Arun District Council
Arun Civic Centre
Maltravers Road
Littlehampton
West Sussex BN17 5LF
Planning & Building Control General Enquiries
Tel: (01903) 737756 Fax: (01903) 730442
Dx: 57406 Littlehampton
Minicom: 01903 732765
e-mail: planning@arun.gov.uk
website: www.arun.gov.uk/planning

Application No: K/1/22/HH
Site Address: Nantucket Gorse Avenue East Preston BN16 1SG
Description of works: Proposed outbuilding to supersede previous outbuilding consented under application reference No. K/23/19/HH.

Thank you for your internet representation made on 13th March 2022 which has been recorded as an objection with the comments as follows:

Drawing Name
**Site Plan -
Proposed**

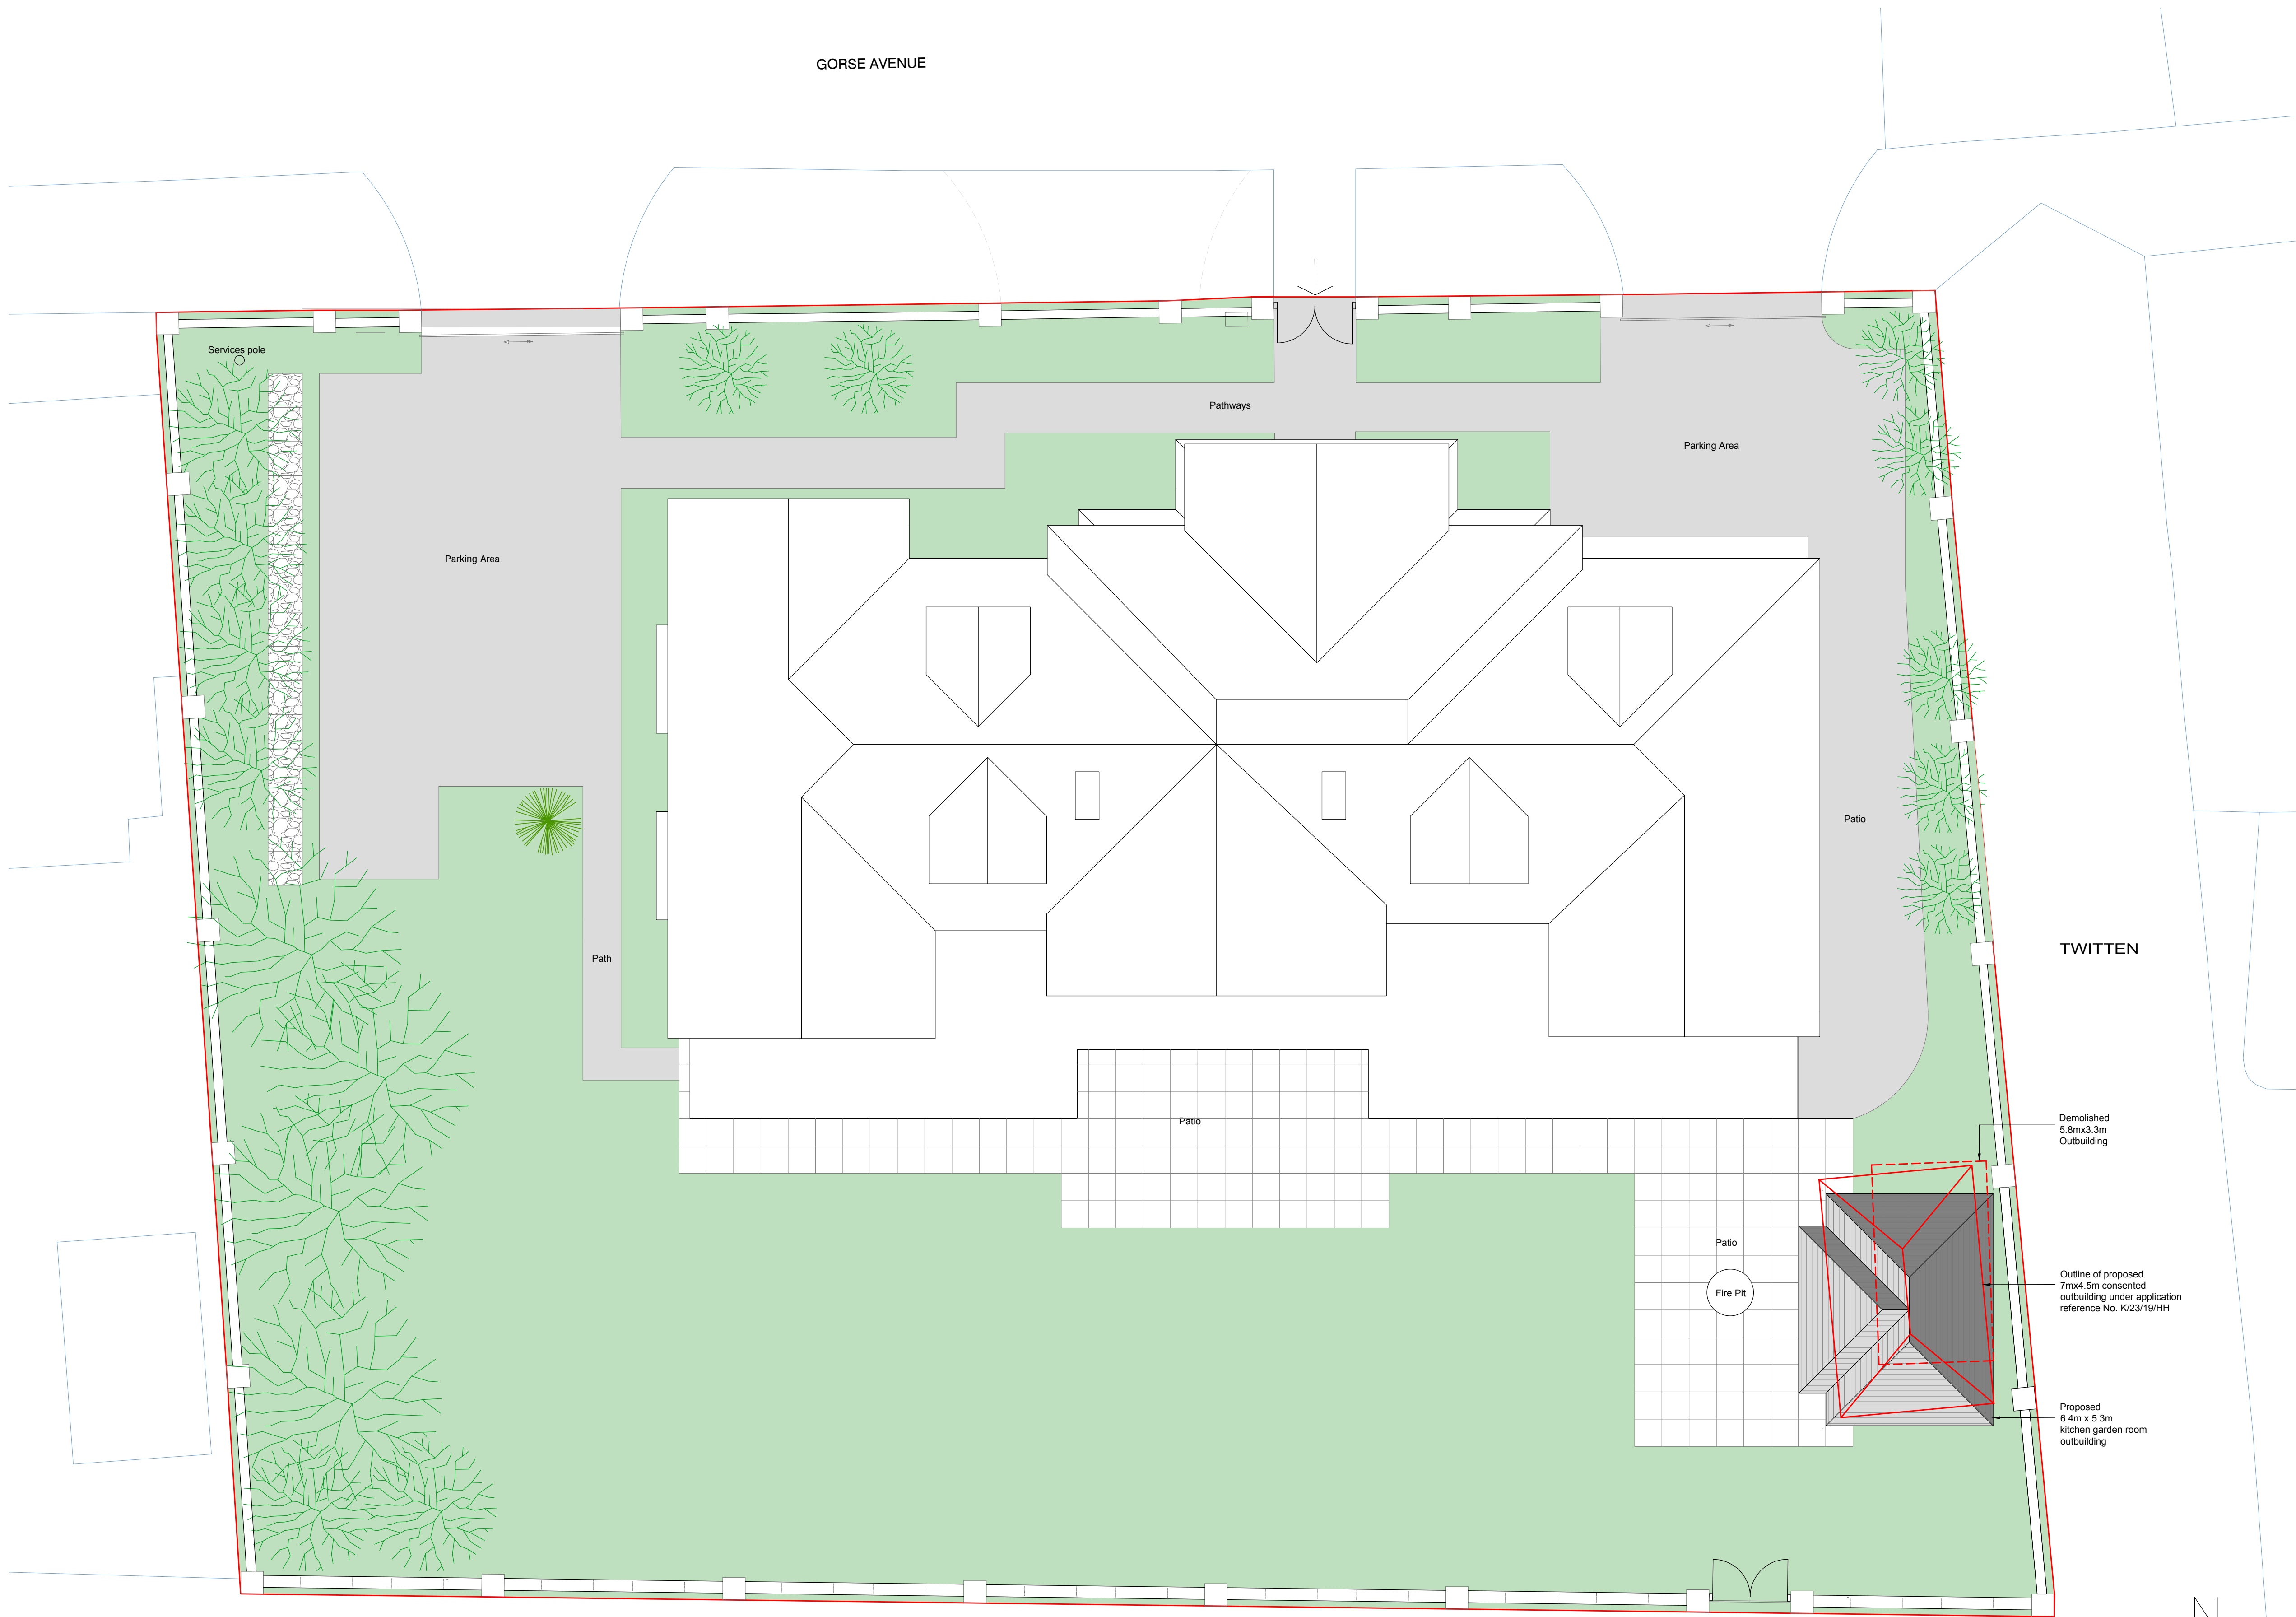
It is intended that the proposed structure be built along the property's garden east boundary wall.

Drawing Name	Floor Plans and Elevations - Proposed
--------------	--

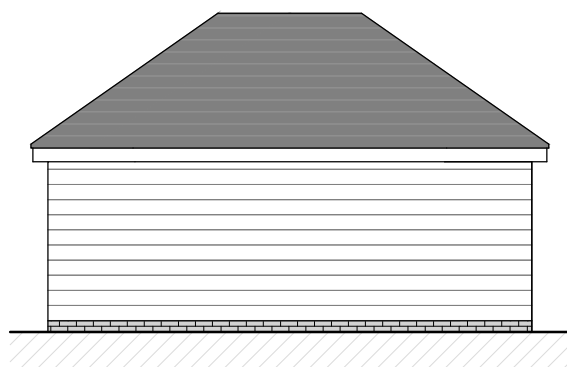
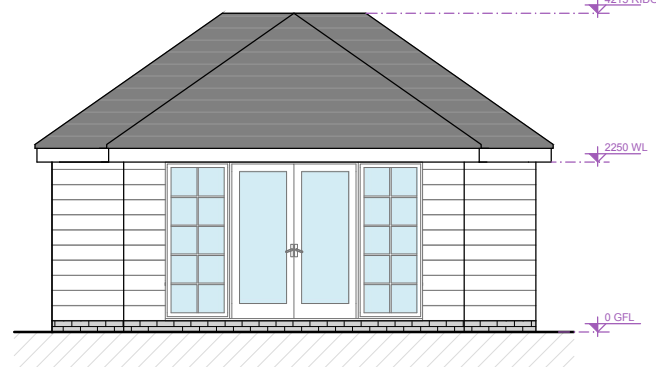
The height of proposed building is 4.3m. The garden boundary wall is only 1.9m. The previous structure was the height of the garden boundary wall.

The pitch roof of the proposed outbuilding will overshadow Tumbley's (the neighbouring property) garden study and sitting room.

Ground Floor Plan
1: 50

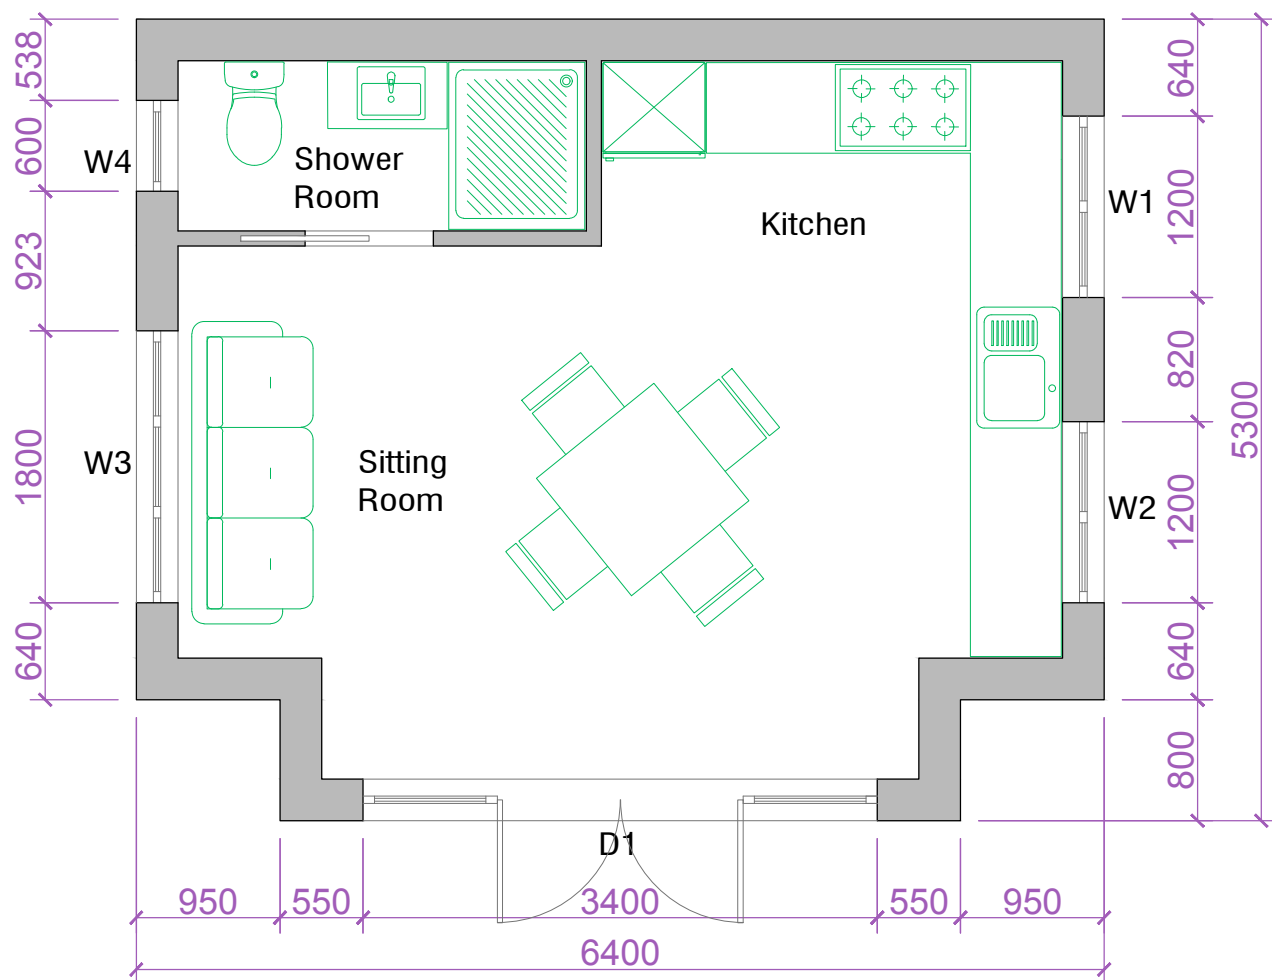
photograph attached). Nantucket is already an overdeveloped site and the new proposed outbuilding with a kitchen, bathroom and sitting room could be considered as an independent dwelling in its own right.
